## Office of Environment & Heritage

### **RE: Cobbora Coal Project – Response to PAC Recommendations and revised Project Preferred Project Report**

I refer to your request received on 14 August 2013, seeking comment from the Office of Environment and Heritage (OEH) on the response to the Planning Assessment Commission (PAC) recommendations and revised Preferred Project Report (PPR) for the Cobbora Coal Project. Please accept our apologies for the delay in our response.

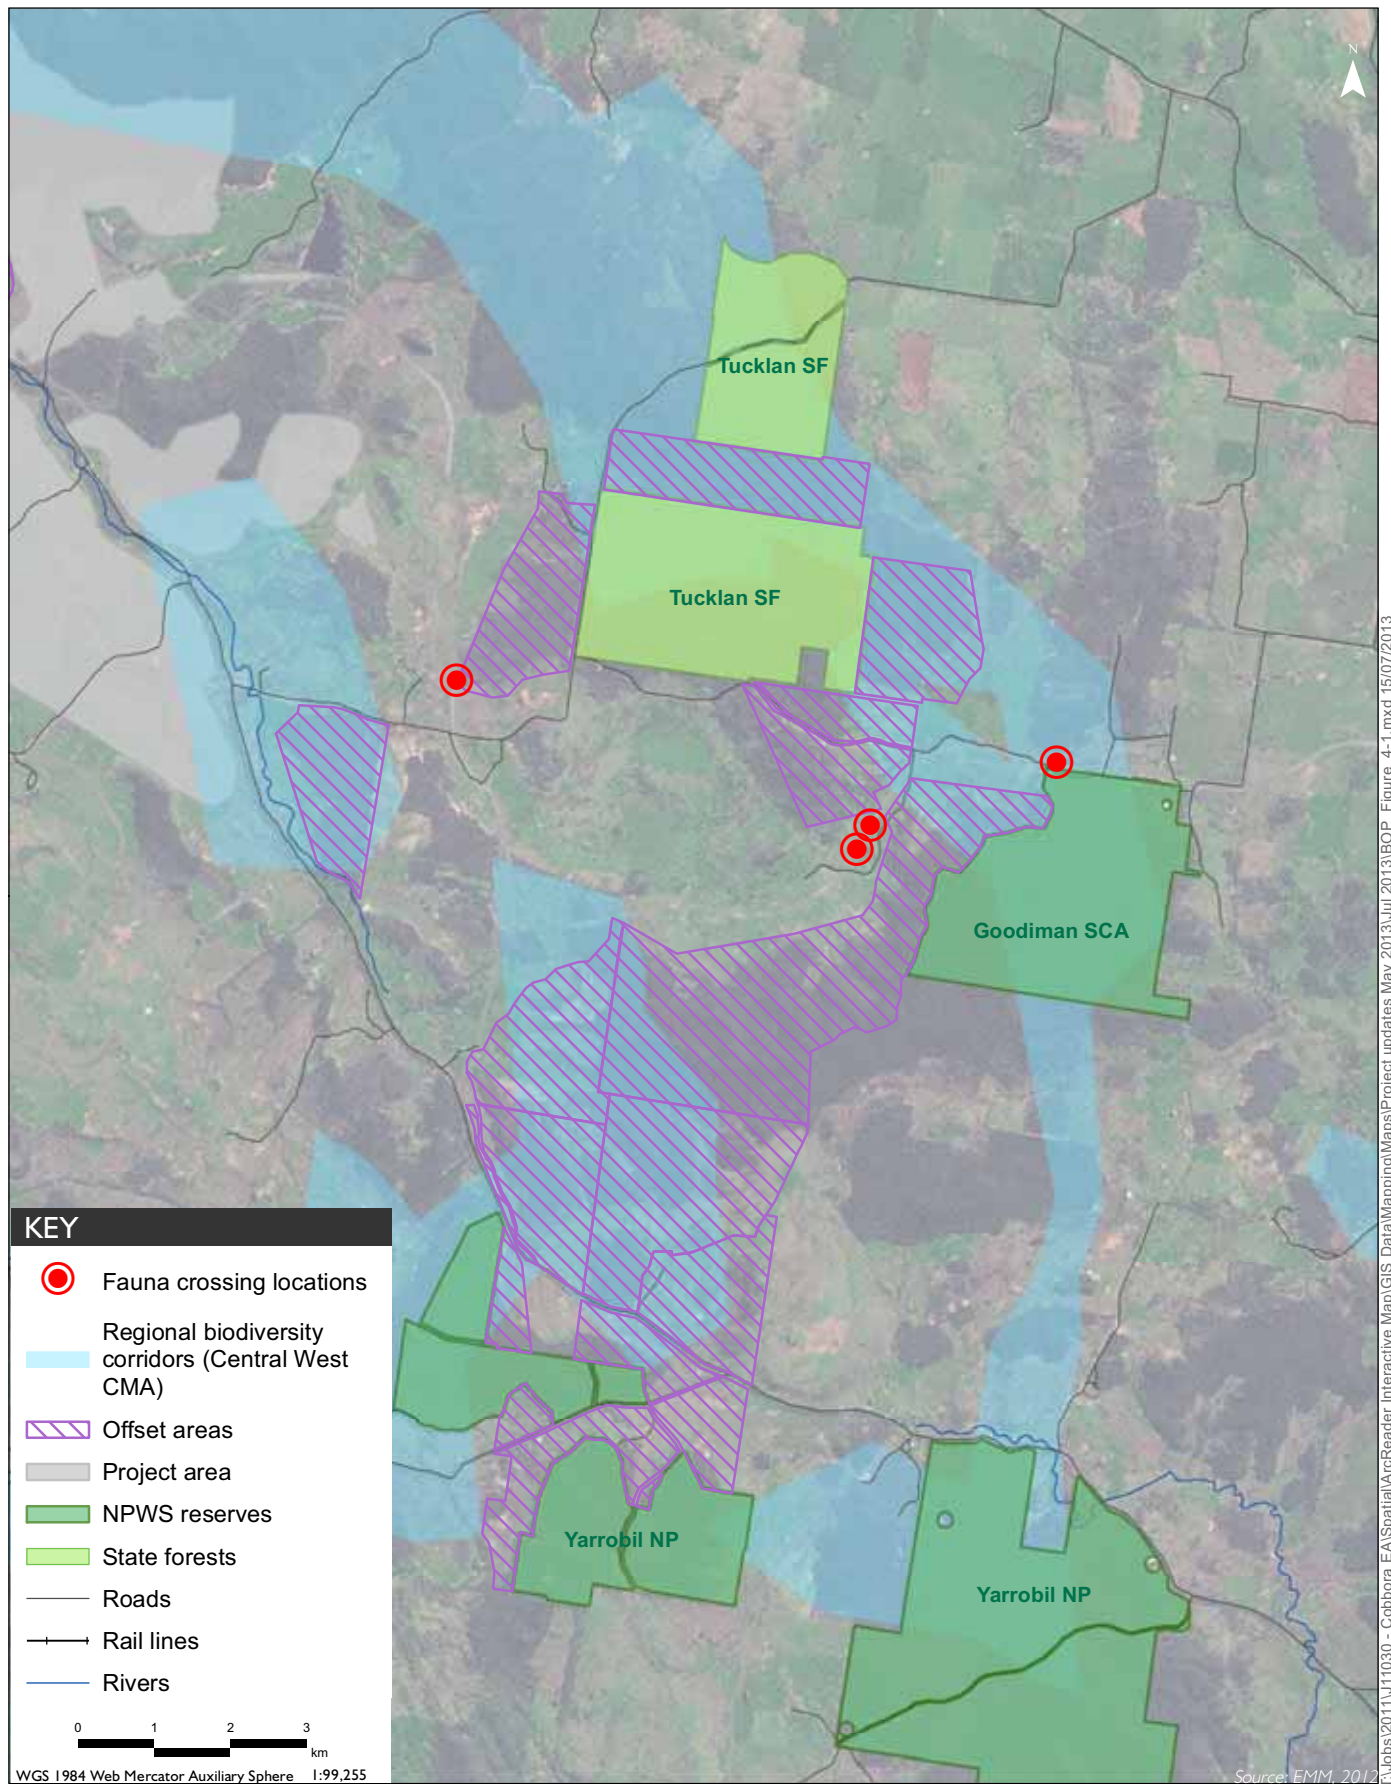
The revised BOP also presents general information on how the design and placement of the proposed fauna movement structures have been chosen. However it remains unclear why an overpass has only been considered for one location.

OEH recommends that any approval conditions relating to the development of the ILMP (or similar plan) for the project area require the proponent to fully justify the design and placement of all fauna movement structures and monitor their usage.
